From: Nicola Swann [REDACTED]
Sent: 21 October 2021 11:22
To: Planning.Responses <Planning.Responses@arun.gov.uk>
Cc: Cllr. June Hamilton [REDACTED] Cllr. David Huntley [REDACTED]
Dawn Hall [REDACTED]
Subject: P49/21/RES Sefter Rod Pagham

Pagham Parish Council would like to record the following comments against this application, which were registered in respect of P/127/21/RES but are equally relevant to this application:

PLAY & RECREATION STRATEGY

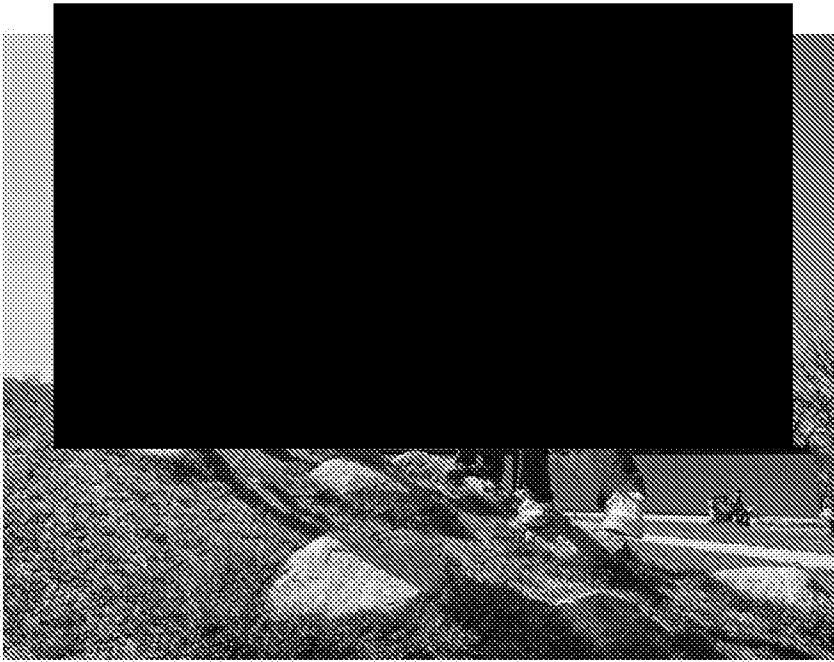
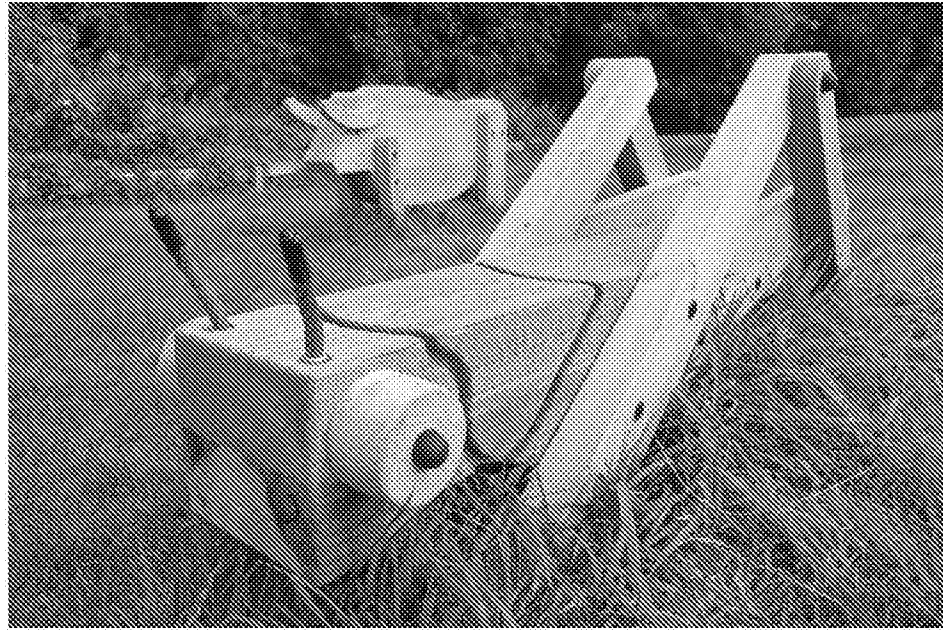
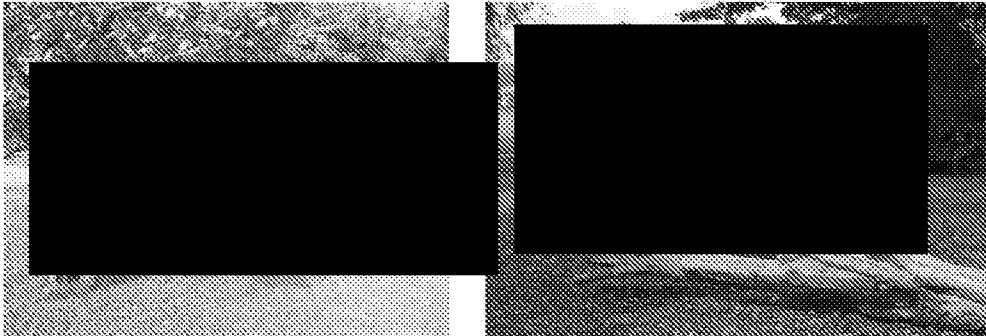
The Parish Council remains concerned over the cramped layout being proposed. Not only is this not in keeping with the rural feel of Pagham, it has lead to a poor parking layout. Residents will not park in their allotted spaces where they are aligned one behind the other. They will park on the roads and verges instead. We would urge the developer to ensure that planting on the verges discourages this. In relation to the houses near the road entrance from Sefter Road, it is unclear how these spaces are accessed. The Council notes that, at Page 49 of the submitted Planning Statement, the developer confirms that it is not meeting the ADC requirement for play space on the site, when calculated by reference to the Open Space and Play calculator. Falling short by 2210m², a huge 73% of the requirement is not being delivered. The developer states that ADC's Leisure and Landscape Officer has endorsed this approach. The Council feels this is unacceptable. The fact that the developer is making a contribution to a MUGA outside the parish in Avisford Park should not abrogate its responsibility to provide play space in line with the calculator. Future residents of this estate, and current residents of Pagham who live nearby, are being short-changed. The ELAP can only be accessed by those living in the Southern Quarter by crossing the spine road. A play area with the safest possible access should be provided for all areas of the site.

External Enclosures  
PLAN

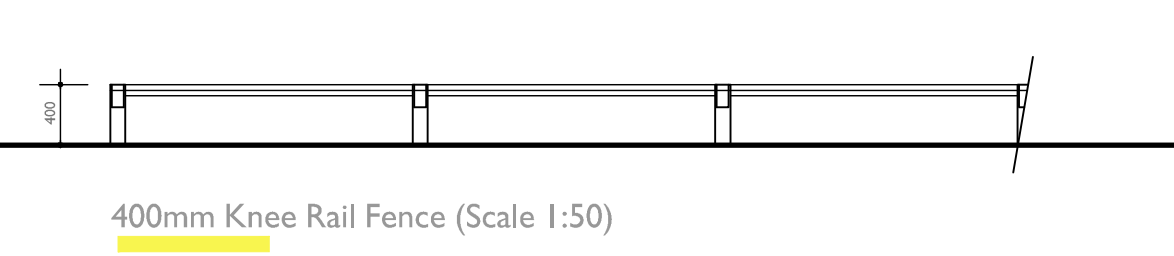
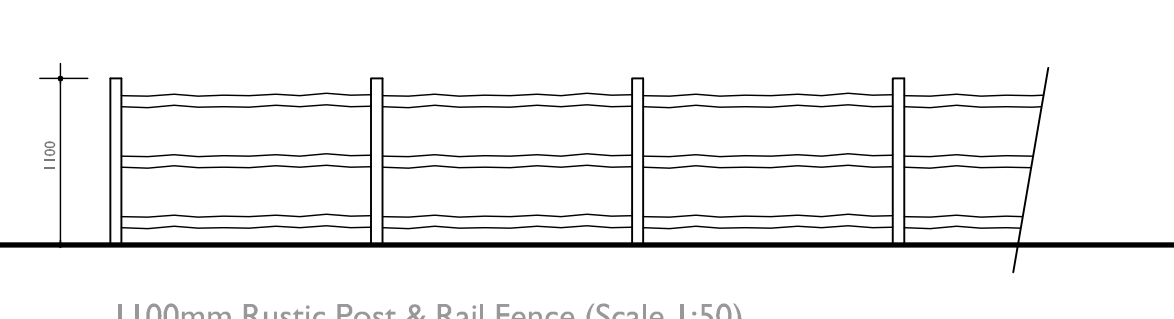
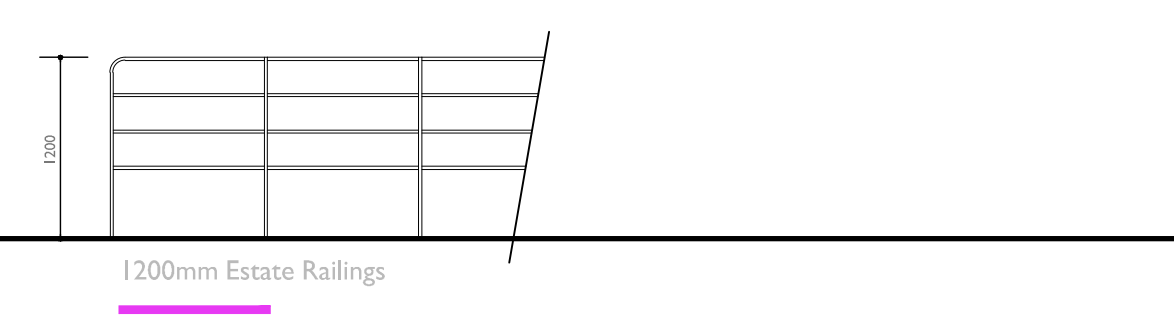
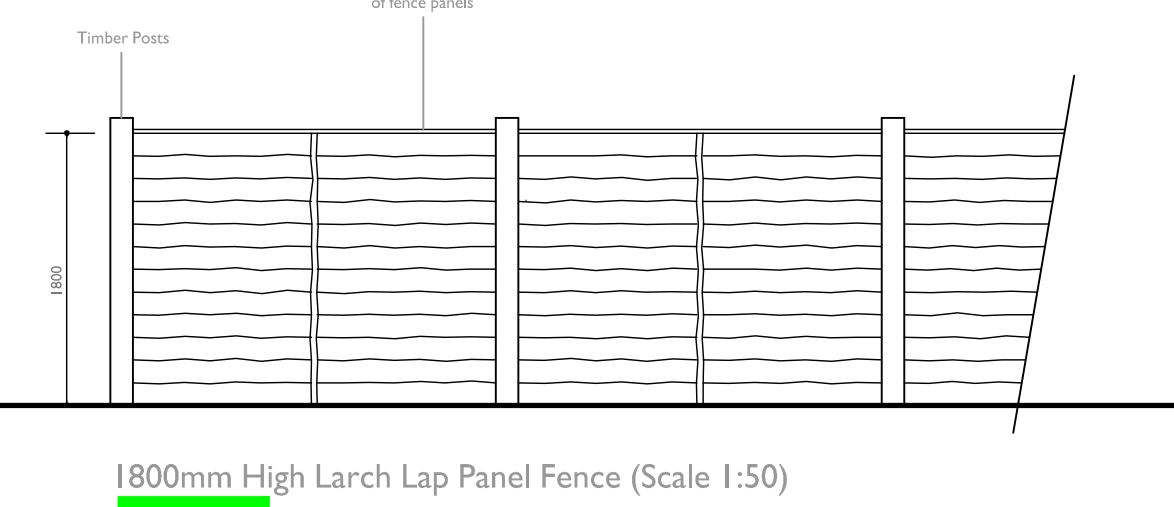
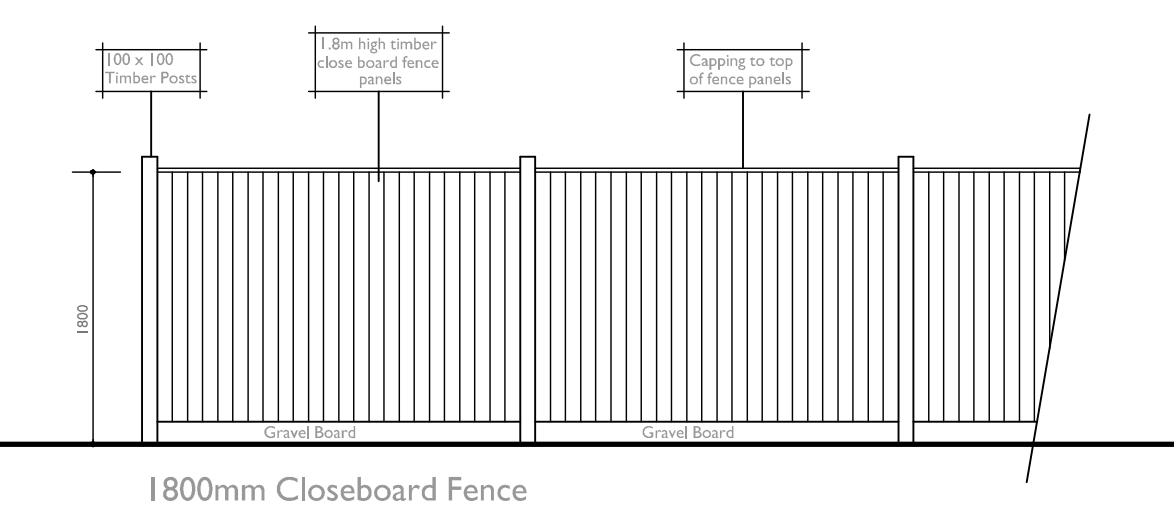
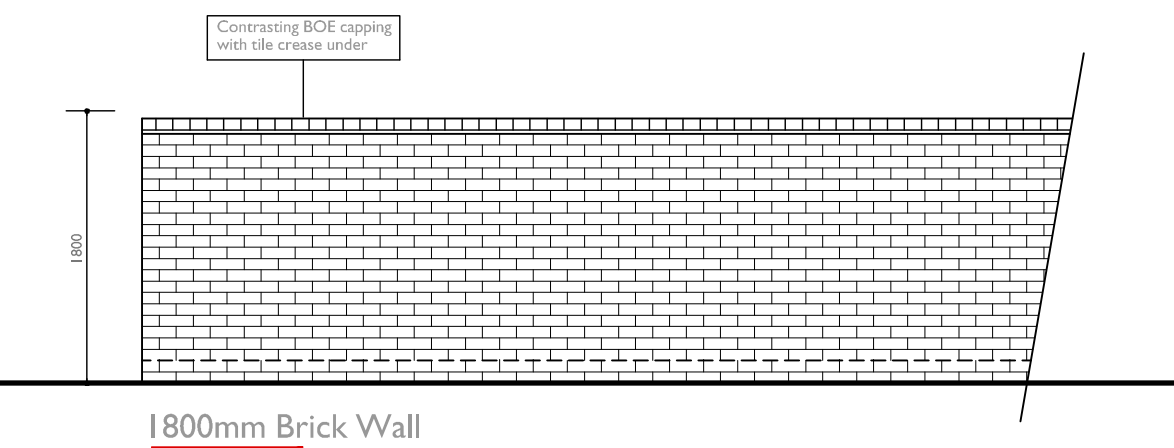
In relation to the Scout Hut, we feel this should have a lockable gate and a gantry to deter unauthorised access. The parking is insufficient at 12 spaces, a point which has been made in response to previous applications. 25 children regularly attend a session, and some of the spaces will be taken up by adult volunteers and the Scouts minibus. This will lead to parking in the road which could delay or block the exit from the Ambulance Response Post situated next to the carpark. There needs to be double yellow lines along the frontage of the scout hut and car park, and a yellow box junction outside the ambulance response post.

At the time of writing, there is no comment from the Council's drainage engineer in response to the proposals for a drainage scheme for the site. Given the well-established problems with flooding on the site it is essential that the scheme receive approval from ADC's drainage engineers before the reserved matters is approved. In addition, the scheme must ensure the issues of flooding in Lincoln Avenue are addressed or at the very least not made any worse. The Council is concerned around the safety of the SUDS ponds. Fencing should be installed to ensure the safety of children.
